Application for a Non-Material Amendment Following a Grant of Planning Permission

Demolition of existing structures and erection of 1 no. single-storey dwelling house.

DC/23/01407

- Revised drawings to show the new roof light to bedroom and annotation regarding west elevation gable frames
- Revised Site Plan to show the addition of the rooflight in the roof plan.

Drawing Title:
Proposed Elevations
Sheet 2

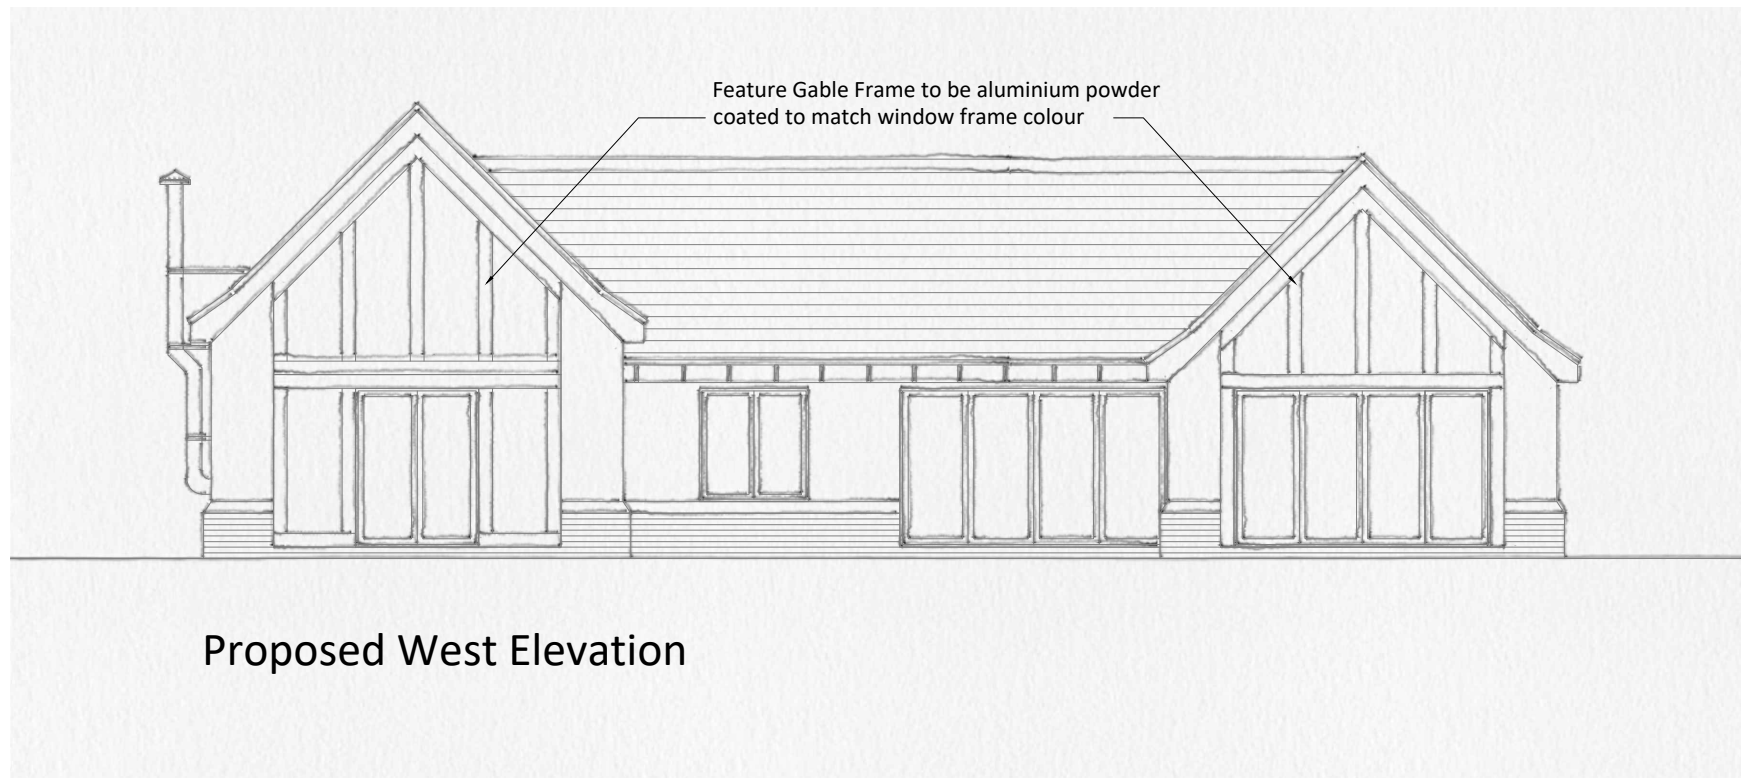
To improve natural light levels to bedroom. Gable material change to match glazing units in these locations
